August 9, 2013

**Subject: Proposed Truck Loading Area – 56 Milliken Street
Application ID: 2013-181
Comments from City of Portland Staff**

FST has received your memos and reviewed the comments (*italicized*) on the above referenced project. Your comments (*italicized*) and our responses (**bold**) are as follows:

SHEET TITLE
PHOTOMETRIC PLAN

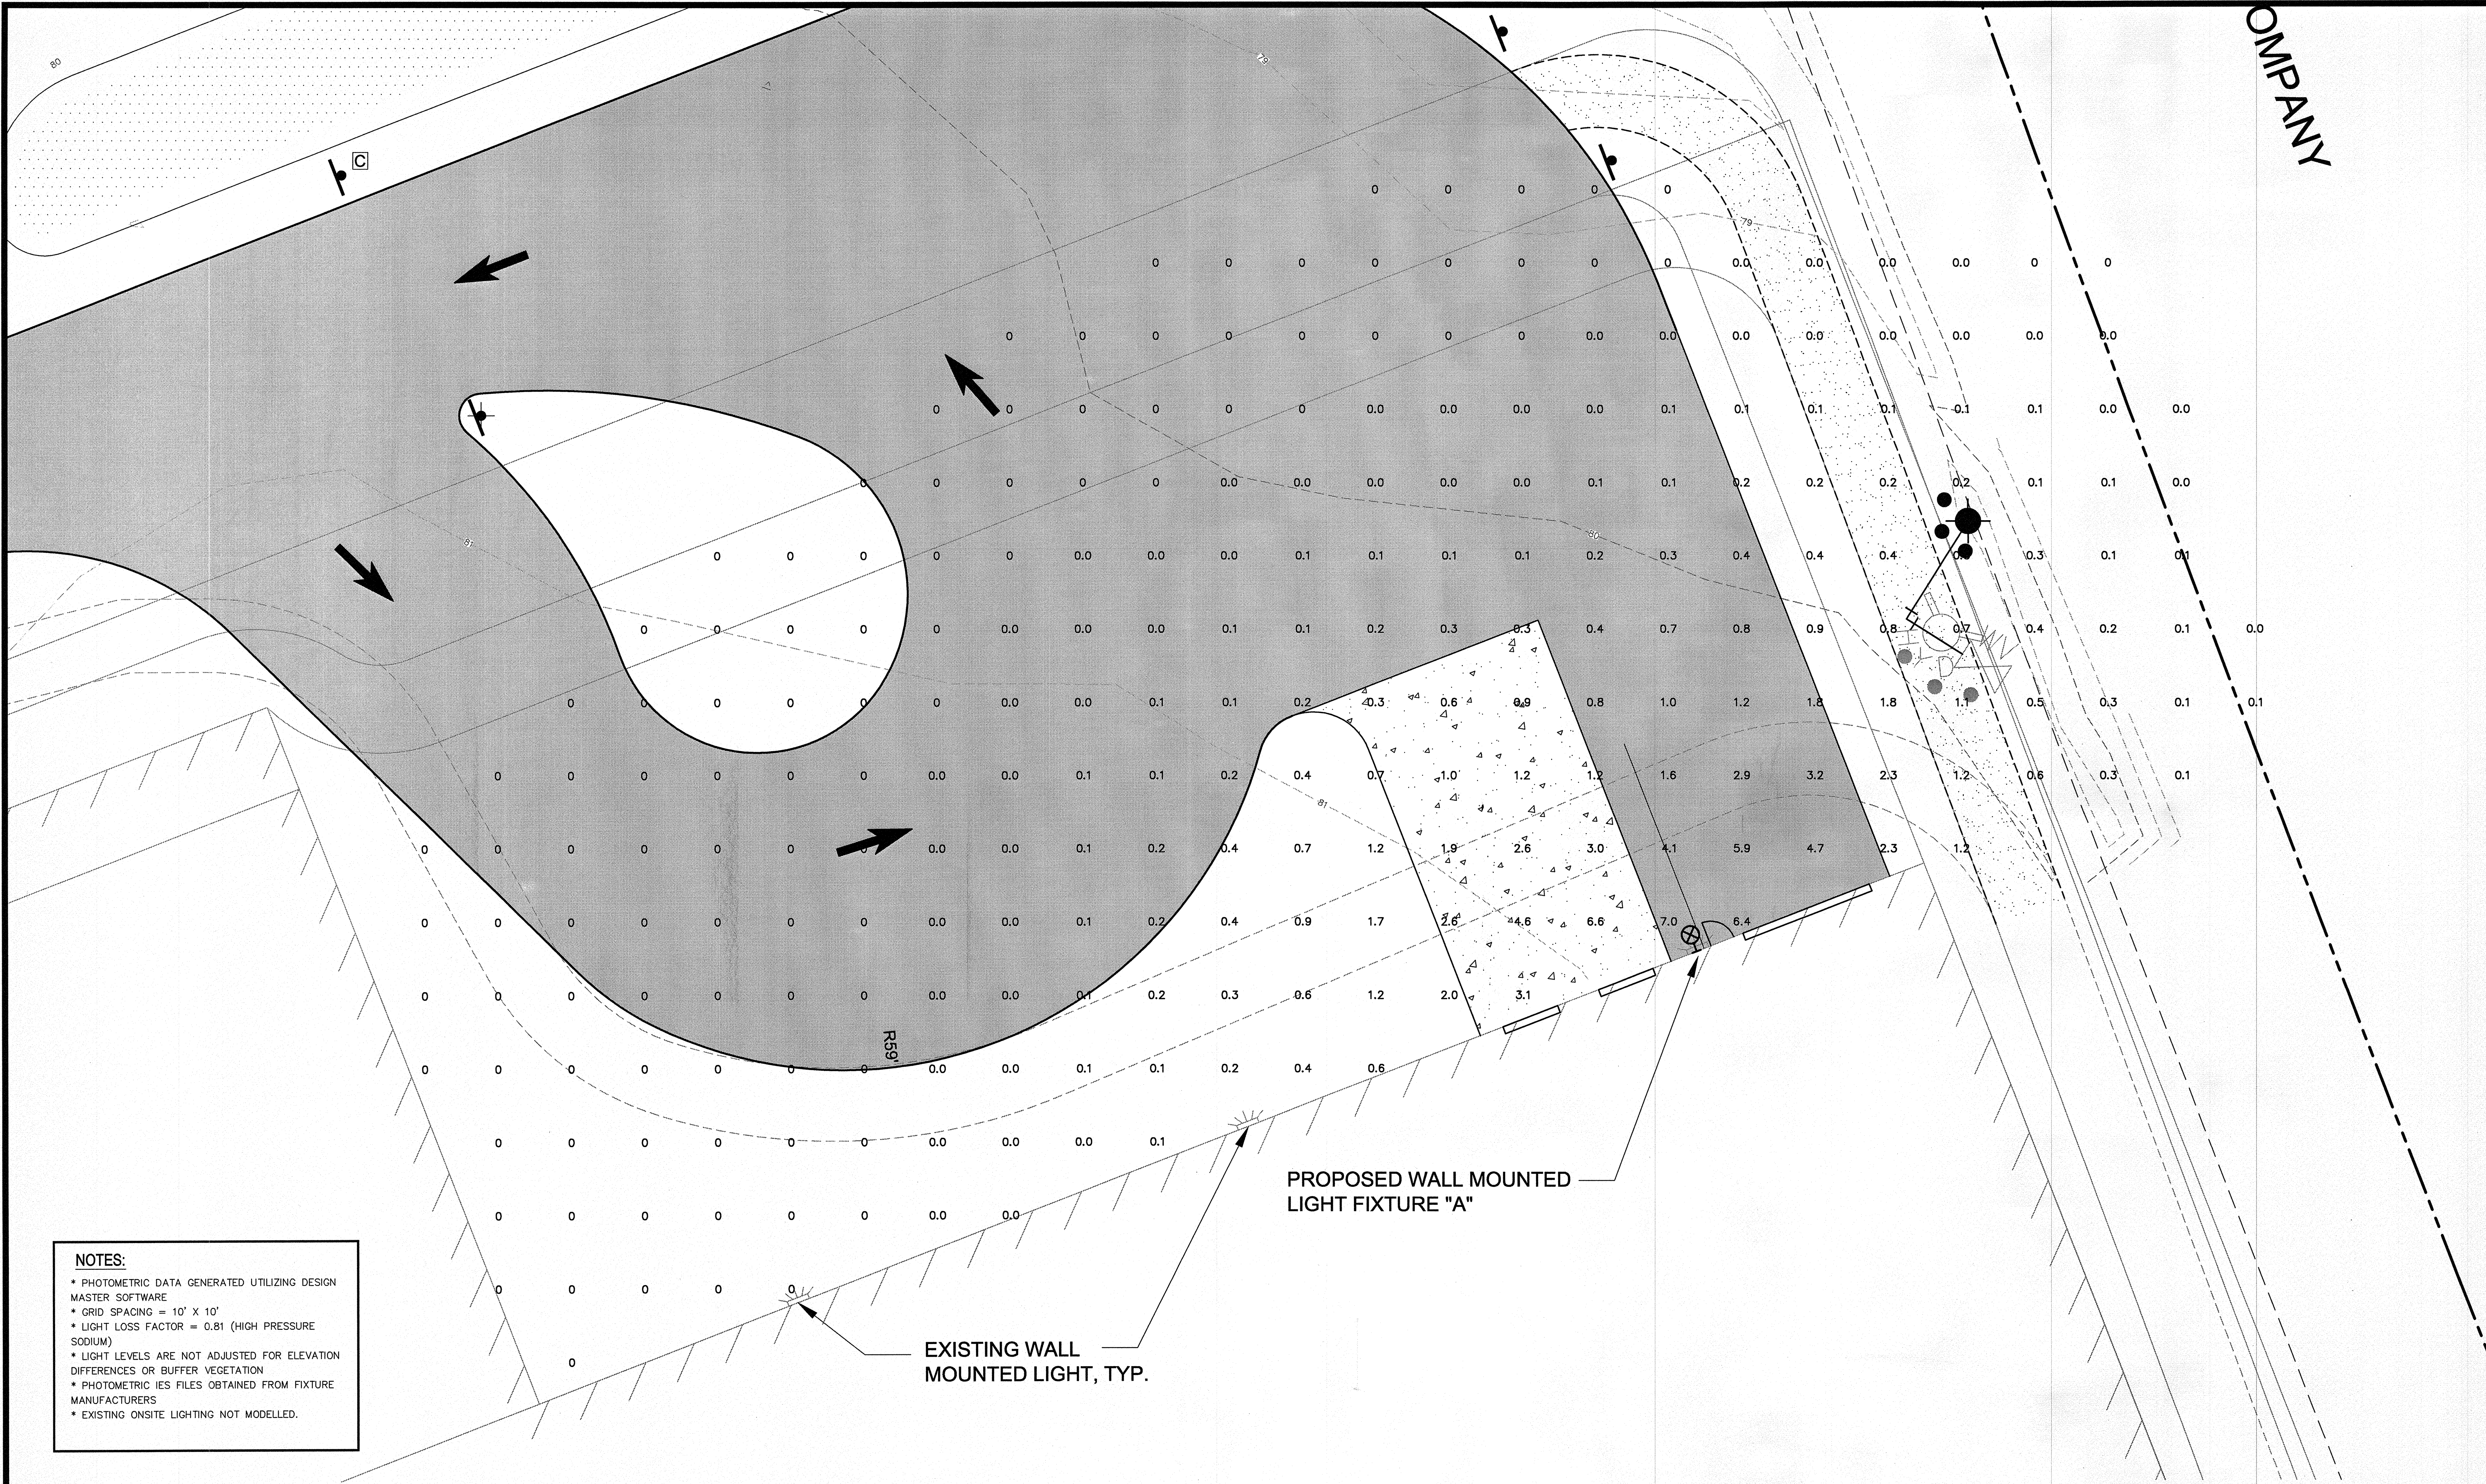
Will there be any new lighting being proposed? If so, please provide lighting catalogue cuts and show location on site plans. We will also need photometric plans.

Sheet C-4.0 is the photometrics plan for the project. This plan only represents the lighting coverage attributable to the new fixtures. A Kim Lighting “wall director” fixture is proposed at the loading dock location. A catalog cut is provided with this letter. We note these are several existing wall mount fixtures along the existing building sidewall. These fixtures provide primarily security level lighting coverage for the relatively isolated site area.
